Mr. Andrew Beattie  
Team Leader – School Infrastructure Assessments  
Department of Planning & Environment  
GPO Box 39  
Sydney NSW 2001

**Alex Avenue Public School (SSD 9368) – Farmland Drive, Schofields  
Notice of Exhibition**

## **TAB A – Comments on SSD application for the Alex Avenue Public School**

Figure 20 | Bus bay and on site drop-off / pick-up area (Bases source: Applicant's SRtS2 2020)

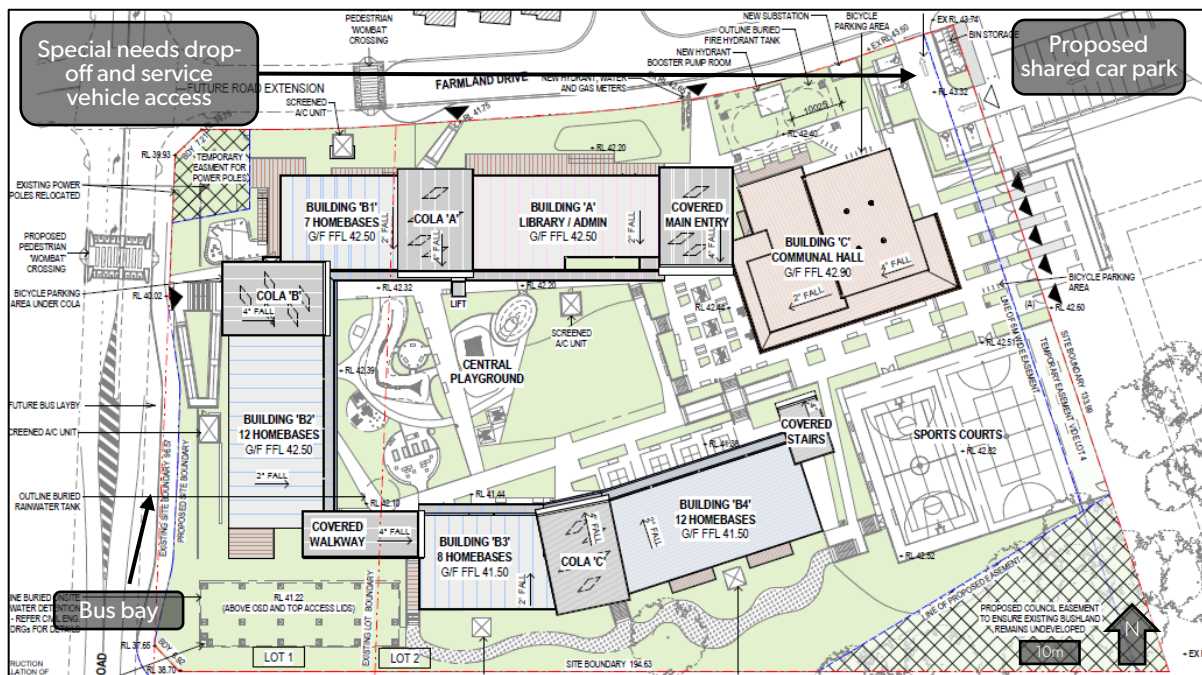
Temporary school bus access would be necessary on Farmland Drive until Pelican Road is open. Bus access would be required for school excursion and sports buses, in addition to regular school buses. During the temporary period, it is anticipated that a limited number of buses would operate on Farmland Drive during daylight hours on school days only. No permanent bus services are planned for Farmland Drive.

- Accommodating a temporary school bus stop within the joint-use car park, with appropriate design for turning buses exiting at the Glacier Street temporary roundabout.
- Providing temporary bus zones on Farmland Drive with the use of nearby local roads to allow buses to return towards Alex Avenue.
